CM/64/21/PL

Land adjacent to Church Farm Barn Horsemere Green Lane Clymping BN17 5QZ

Use of land for Class B8 (Storage) for caravan storage. This application may affect the setting of listed buildings & is in CIL Zone 3 (Zero Rated) as other development

Drawing Title
Site Layout - AS PROPOSED

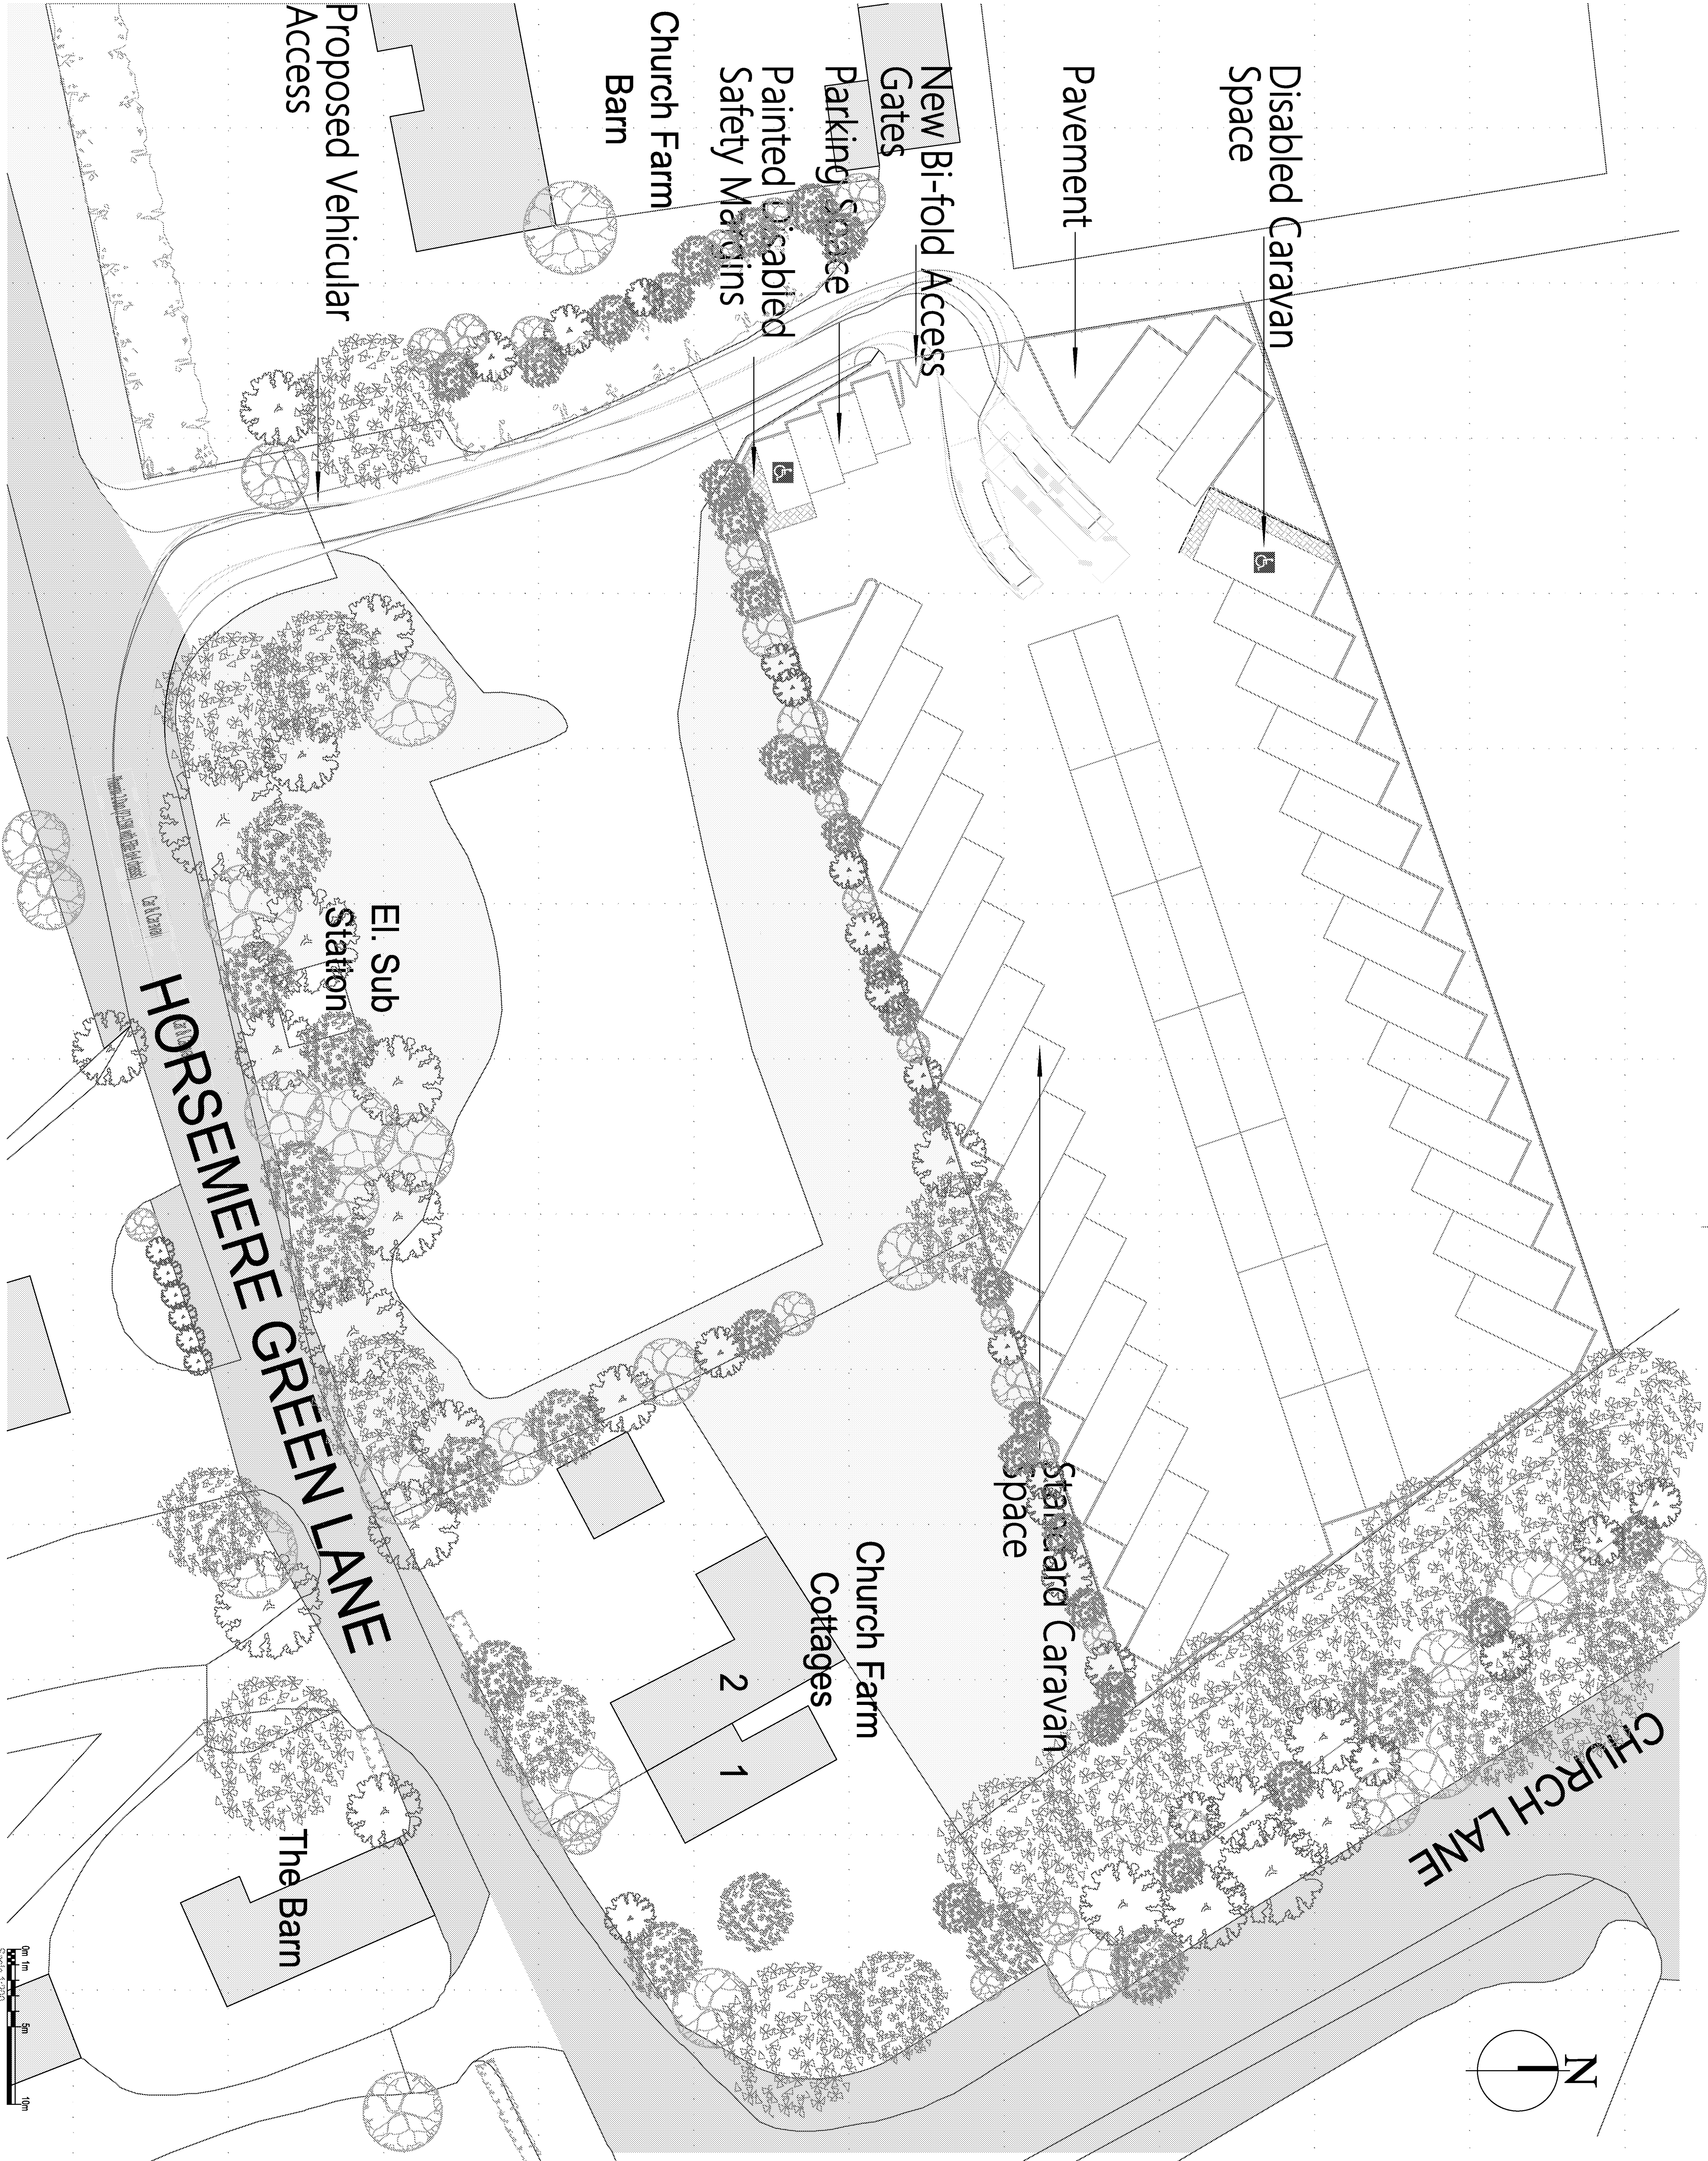
A review of the block plan shows that it does not indicate if there is to be any lighting provided within the site, and if it does, how this will look, or where it would be located. Any lighting should be carefully located and of a design that would not generate excessive levels of light in the evenings, and therefore potentially cause harm.
